Date: 15-Aug-2023
Our Ref: 2023/91857

Prior approval for alterations to Dewsbury Railway Station (Listed Building within a Conservation Area)
Dewsbury Railway Station, Wellington Road, Dewsbury, WF13 1HF
Application Number: 2023/91857

The Council considers that the works detailed in the above application are permitted development under Part 18(A) of Schedule 2 of the Town and Country Planning (General Permitted Development) (England) Order 2015 and that Prior approval for the development is hereby granted subject to the following conditions:

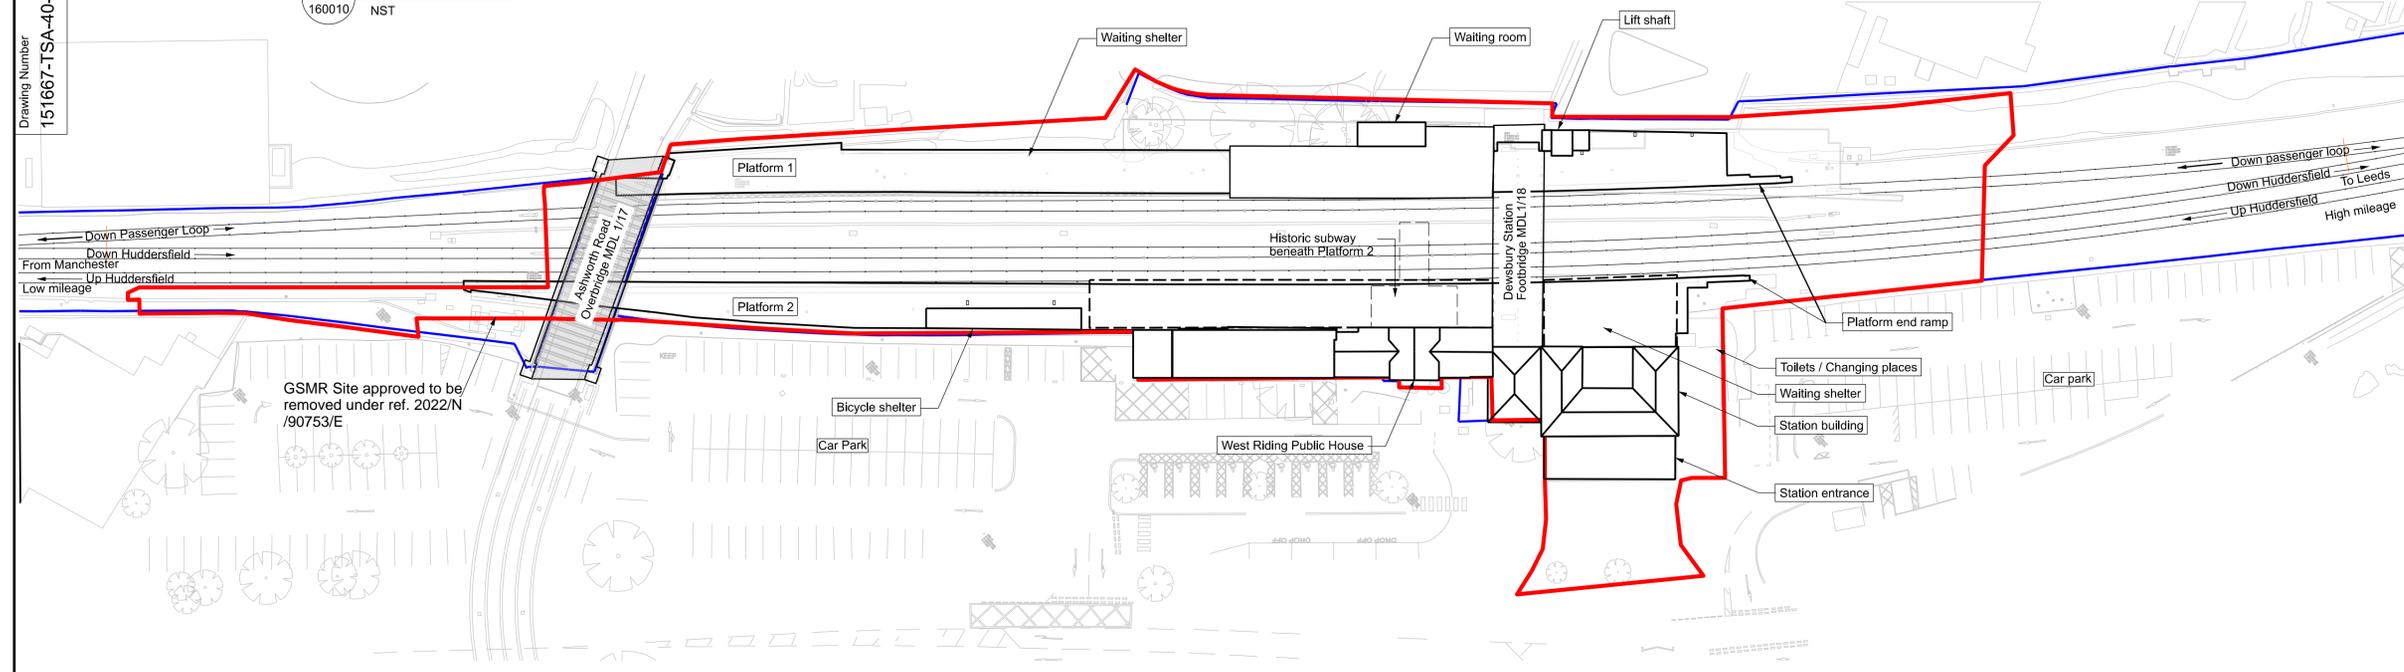
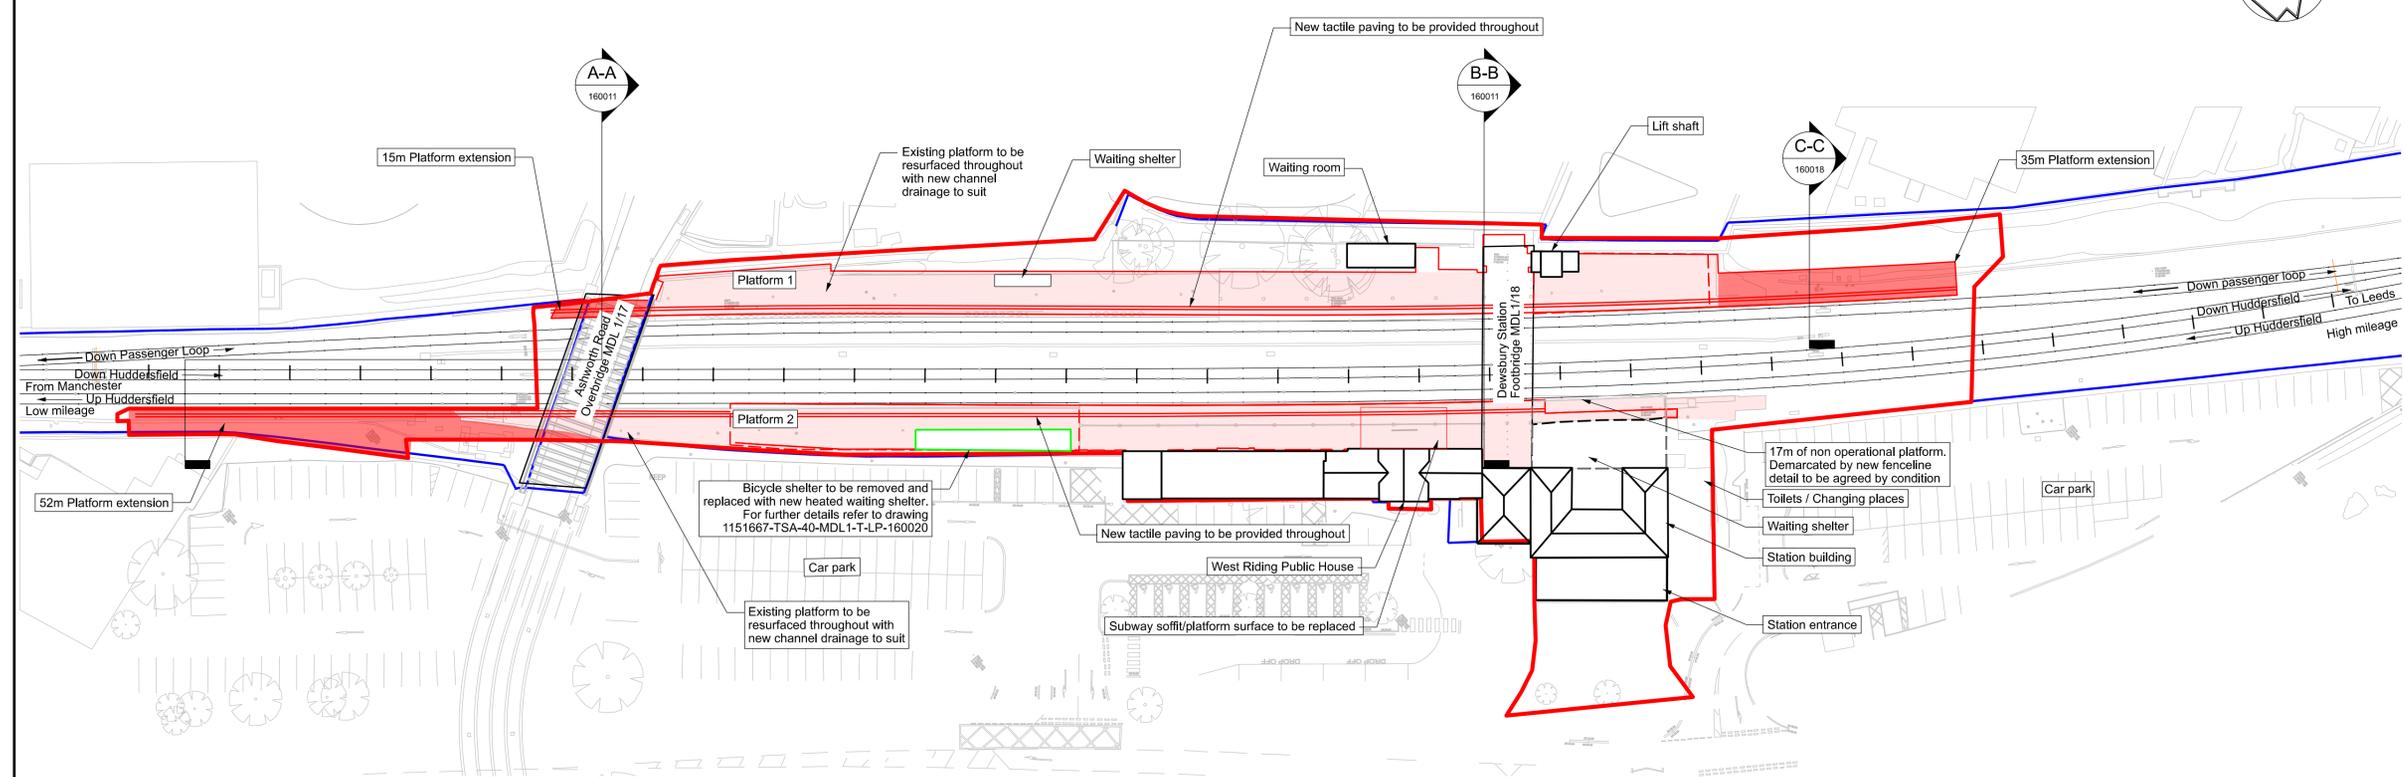
3. The stone string courses which form part of the platform retaining walls, and the platform ramps themselves, shall be retained, including the sections which taper towards the ends of the existing platforms. New masonry for the construction of the extensions shall incorporate these string courses and the ramp formations, to allow the historic platform detailing and lengths to remain legible.

Drawing Title
**Prior Approval
Dewsbury Station
Proposed Canopy Sections
and Connection Details**

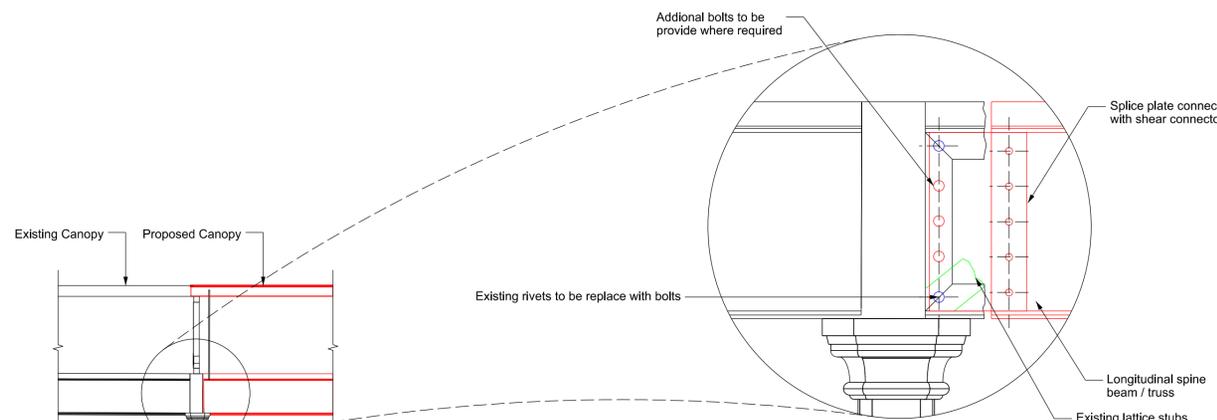
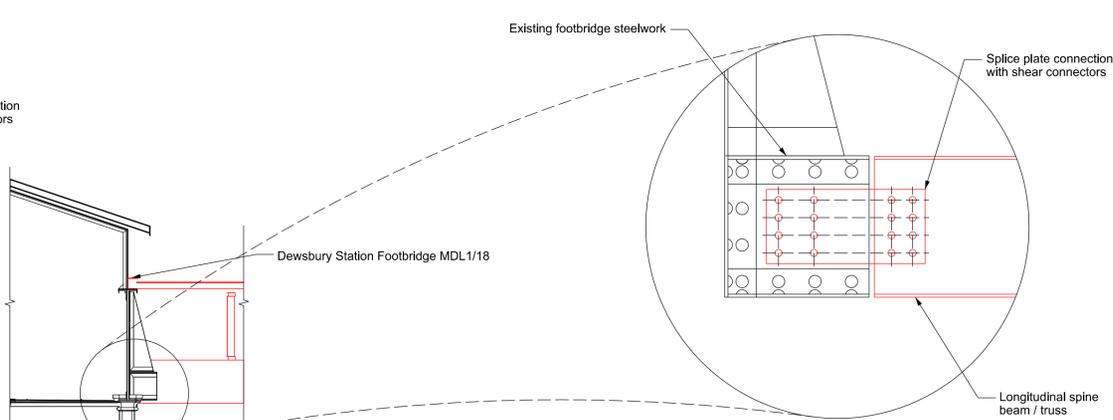
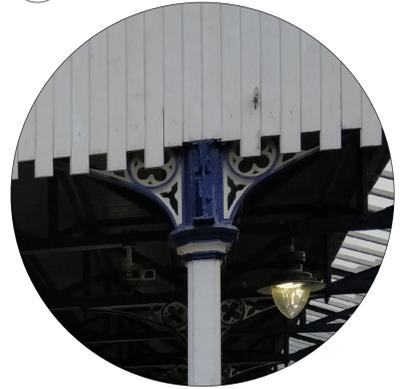
5. Prior to the canopy extensions being installed, the detailed design of the columns and column connections for the canopy extensions on Platforms 1 and 2 shall be submitted to and approved in writing by the Local Planning Authority. Thereafter the development shall be undertaken in accordance with the approved details and be retained.

Transpennine Route Upgrade
Contract No. **151667**
Contract Title **West of Leeds**
Drawing Title **Prior Approval Dewsbury Station Proposed Sections Platforms**

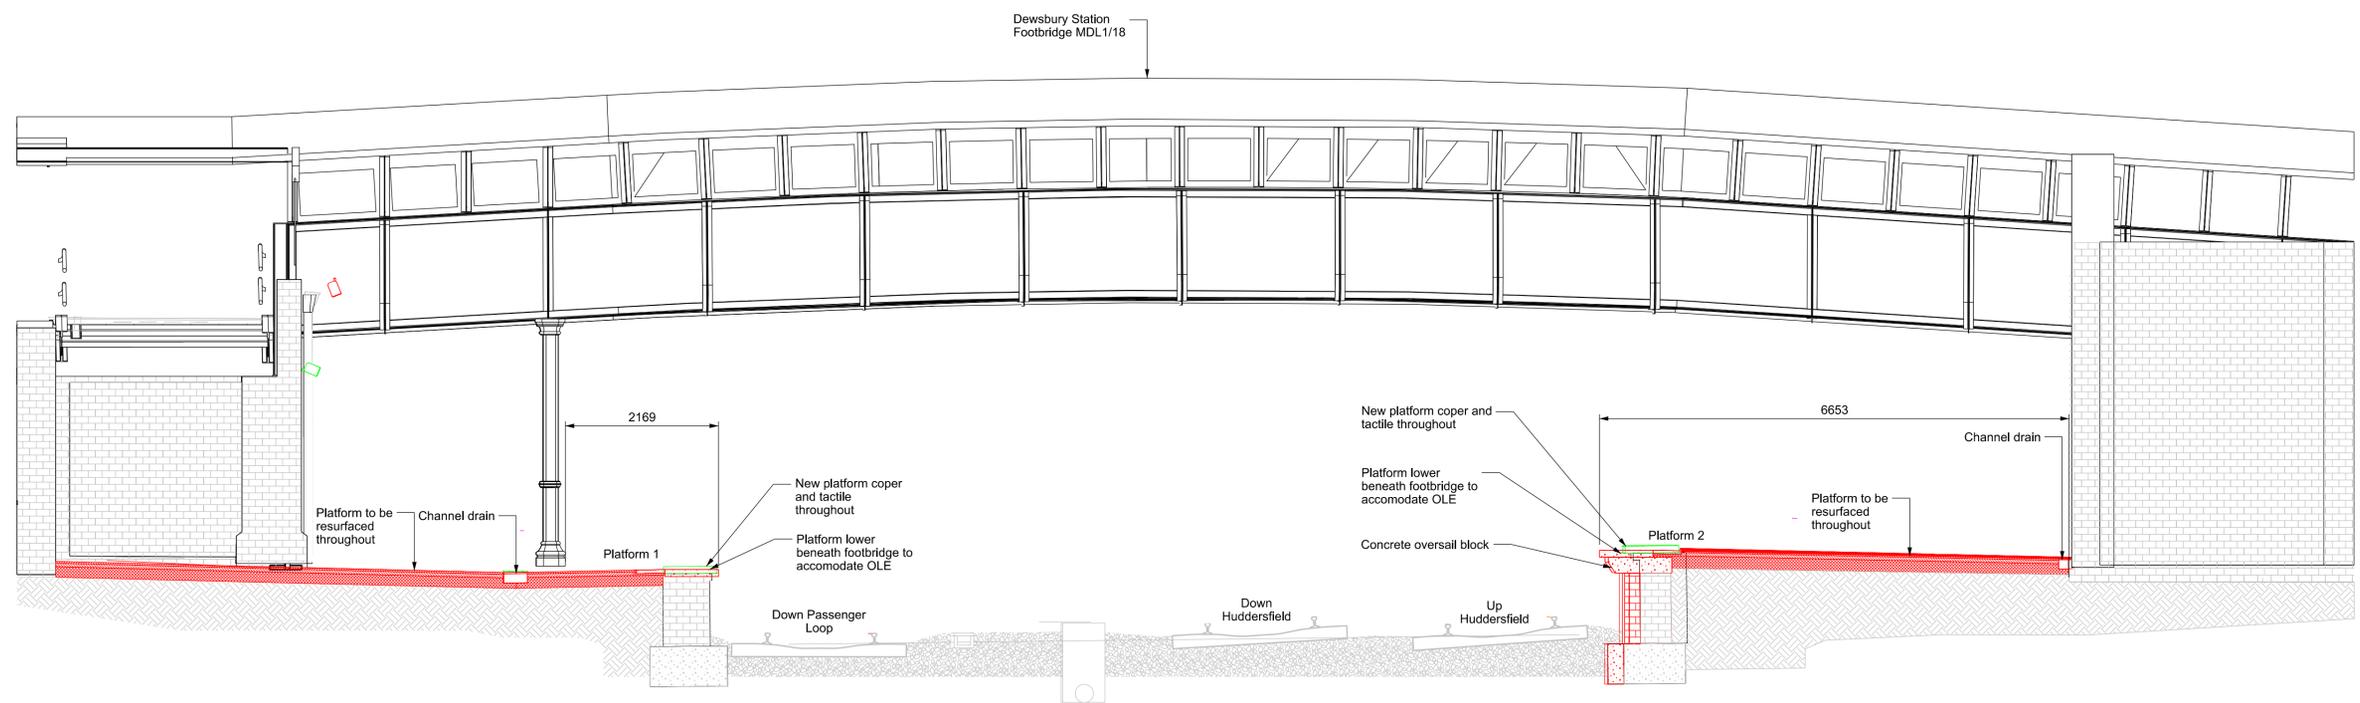
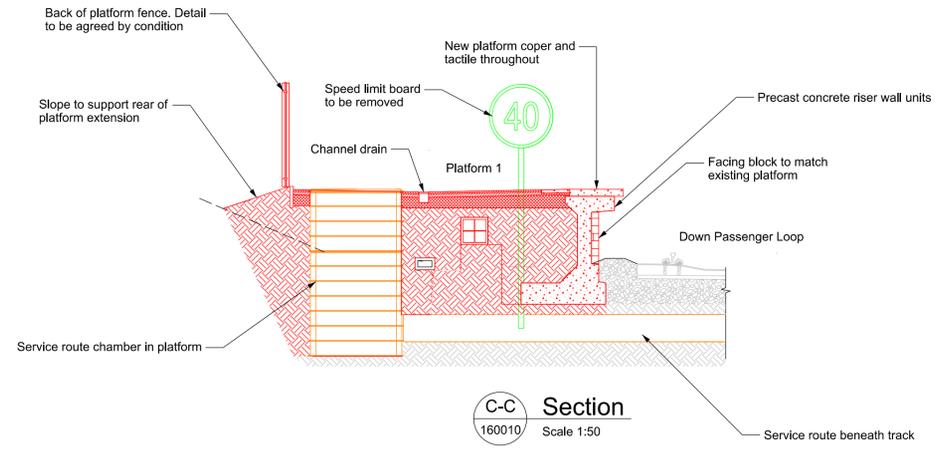
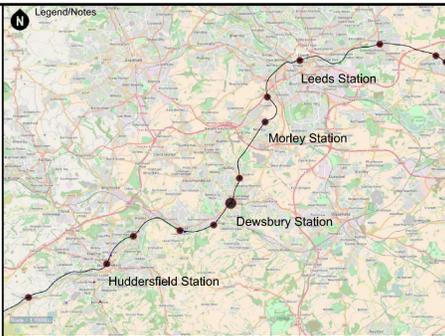
4. Prior to works commencing to the platform extensions, details and materials of the proposed paving, steps and fencing at the platform ends, shall be submitted to and approved in writing by the Local Planning Authority. Thereafter the development shall be undertaken in accordance with the approved details and be retained.
